13/03/2020

**Tomingley Gold Project – Proposed Modification 4 (MP09_0155 MOD 4)
Response to Submissions**

Attachment 1

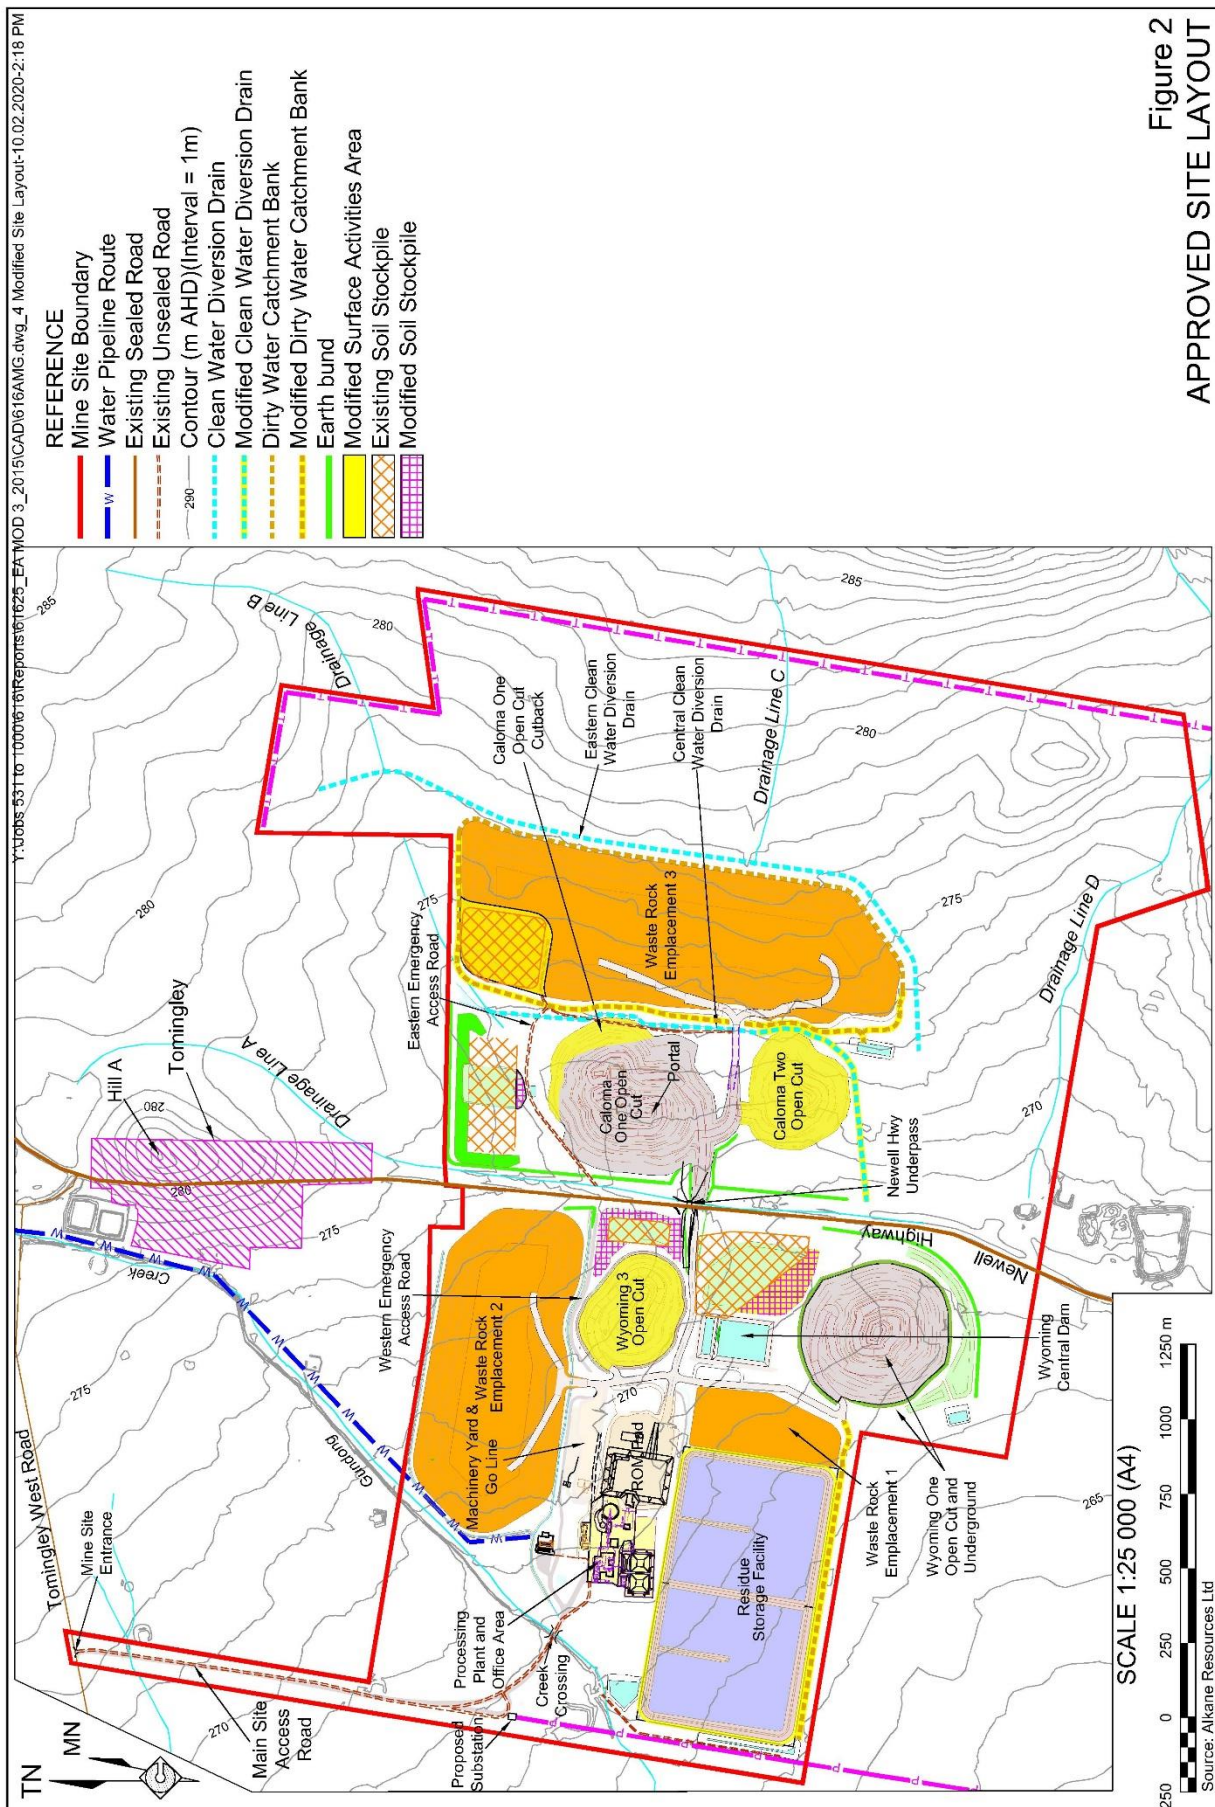
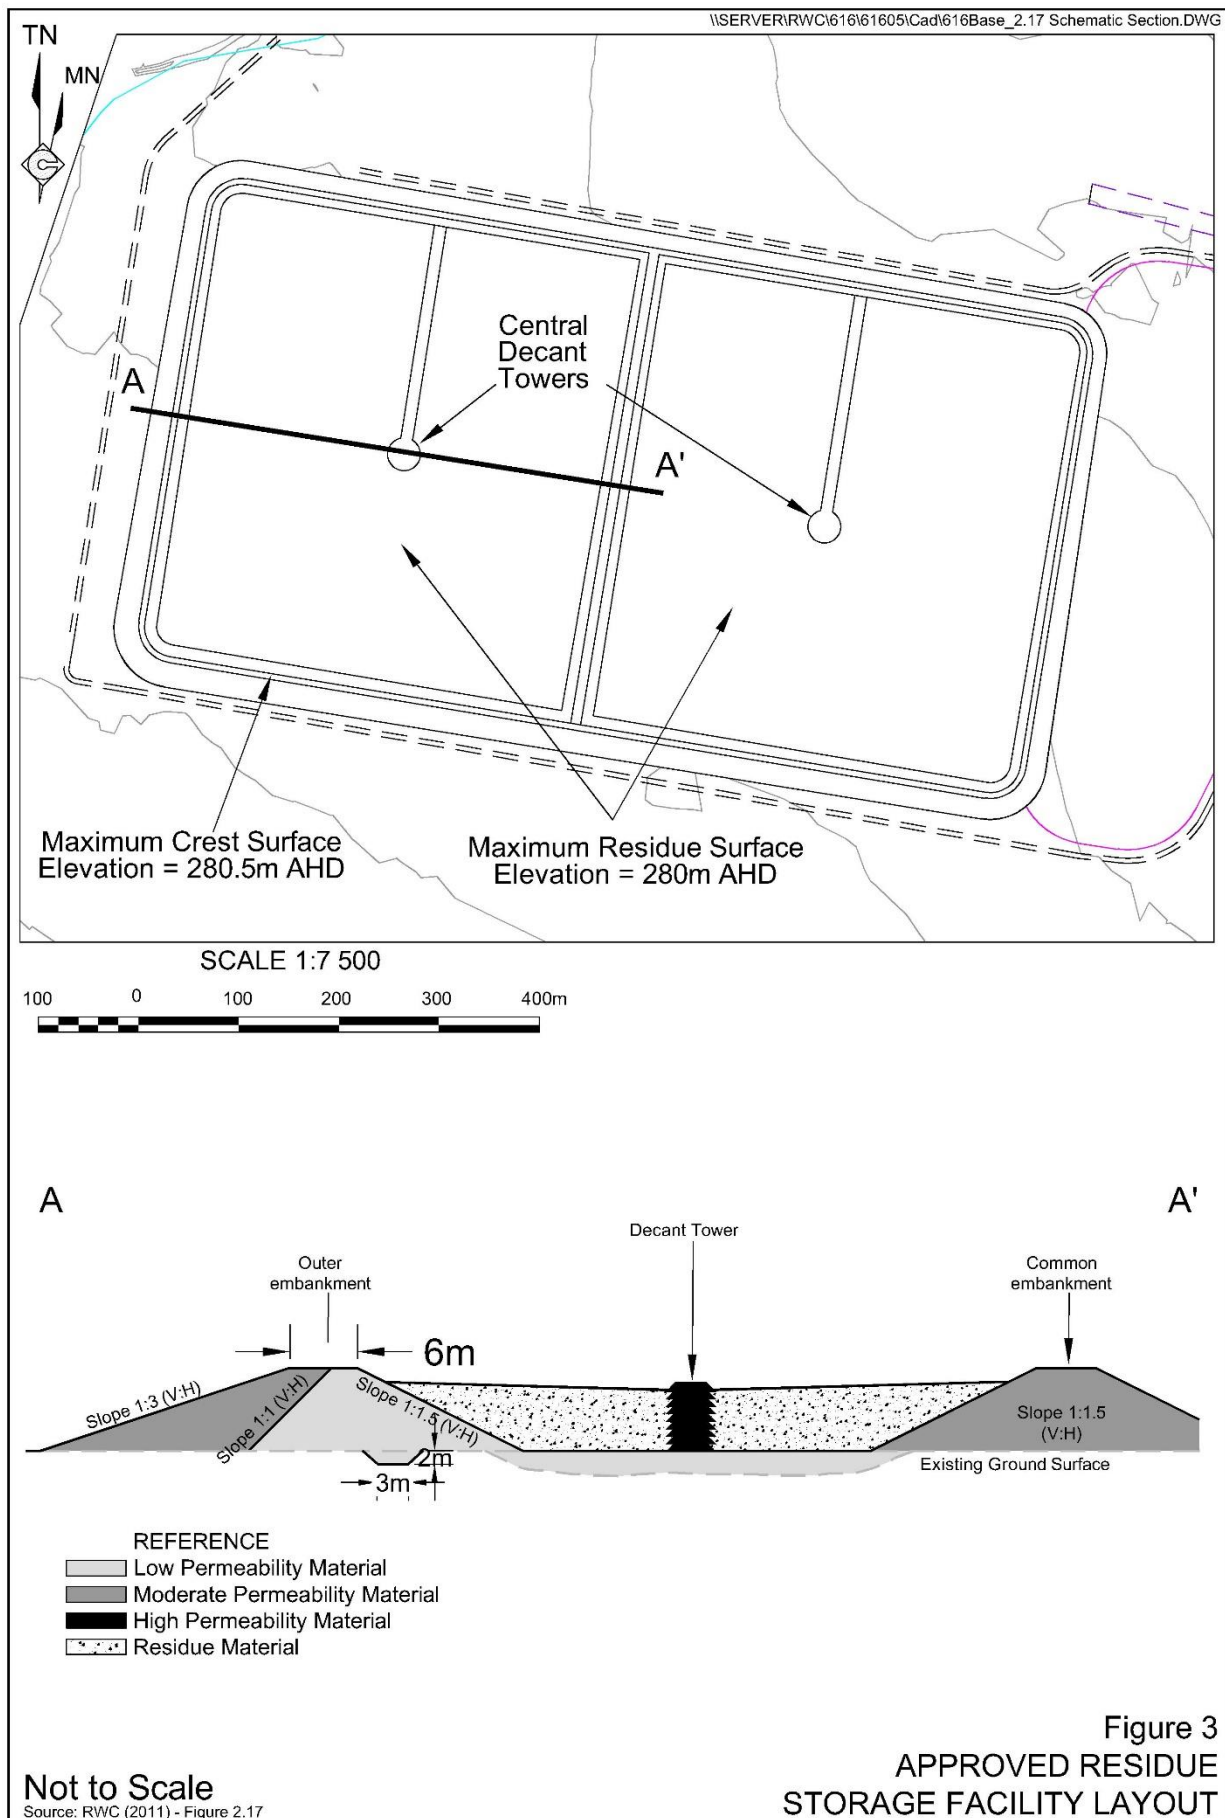
Matter	Consideration
Figures and maps	- Please provide an updated Figure 2 of the Modification Report to reflect all the currently approved infrastructures, and include all the surface water structures (for both processed water and mine water) - Please confirm if the rehabilitation plan map included in the project approval is still current.
RSF	- The RSF area in the original application was 42 ha. Please clarify when it was increased to 50 ha and why the GHD (2019) RSF concept design refers to 40.5 ha for the RSF area (section 2.1). - Section 2.2.2 of the Modification Report: <i>'The approved Residue Storage Facility includes six lifts or Stages, with each constructed using upstream lifts, namely construction of the subsequent lift on previously deposited residue'</i>. However, MOD3 approval involved downstream construction. Please clarify why the Modification Report referred to upstream method in the previous stages of the RSF lifts. - The Modification Report states that material within the project's WREs or on-going mining operations would be used for construction of the modified RSF. Please clarify about the 'mining operation' and the type of material that would result from this operation.
